**Subject:** Rezoning Petition Review

**Rezoning Petition #:** 21-159

**Location of Property:** Approximately 1.25 acres located on the west side of W Sugar Creek Rd, north of Rutgers Ave and south side of Cushman St.

Drawing No. **RZ-1.0**

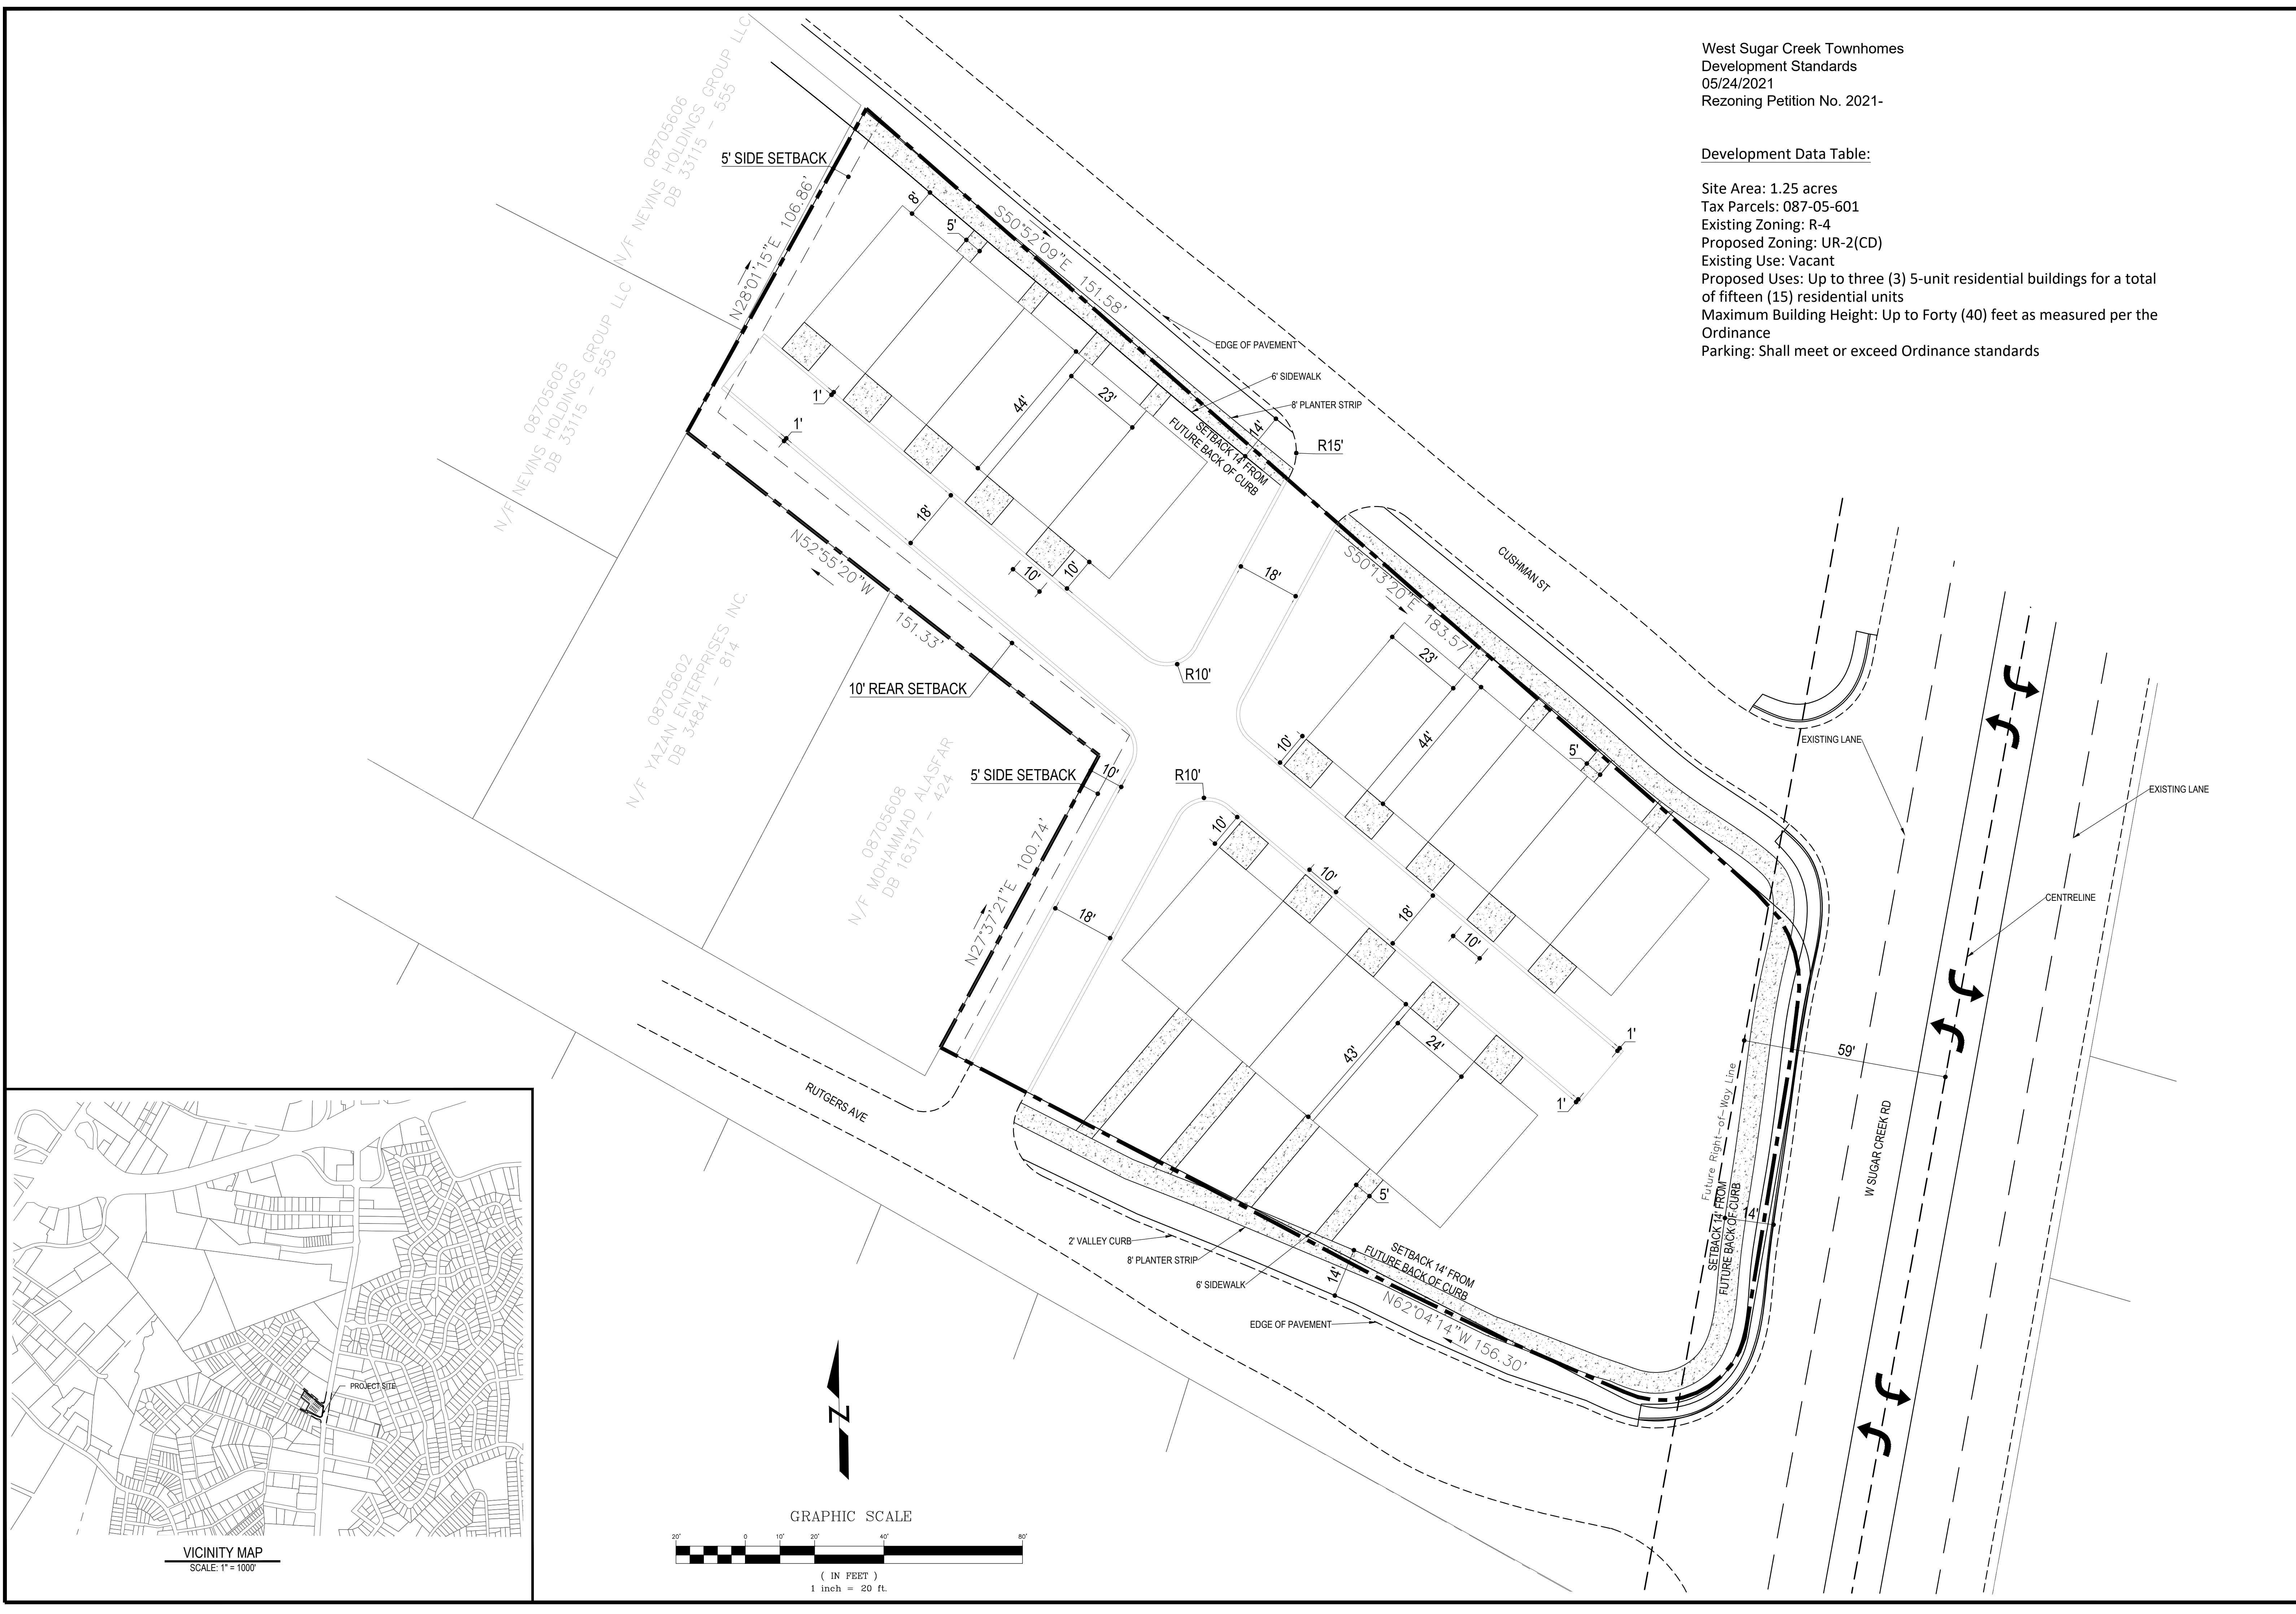
**This property drains to Upper Little Sugar Creek, which is an impaired/degraded stream, and may contribute to downstream flooding. This project has the opportunity to mitigate future impacts to this stream, therefore, Storm Water recommends placing the following notes on the plan:**

For defined watersheds greater than 24% built-upon area (BUA), construct water quality stormwater control measures (SCMs) designed for the runoff generated from the first 1-inch of rainfall for all new and redeveloped BUA associated with the project. SCMs must be designed and constructed in accordance with the Charlotte-Mecklenburg BMP Design Manual.

For defined watersheds greater than 24% built-upon area, control the entire volume for the 1-year, 24-hour storm for all new and redeveloped BUA associated with the project. Runoff volume drawdown time shall be in accordance with the Charlotte-Mecklenburg BMP Design Manual.

For residential projects with greater than 24% BUA, control the peak to not exceed the predevelopment runoff rates for the 10-year and 25-year, 6-hour storms or perform a downstream analysis to determine whether peak control is needed, and if so, for what level of storm frequency.
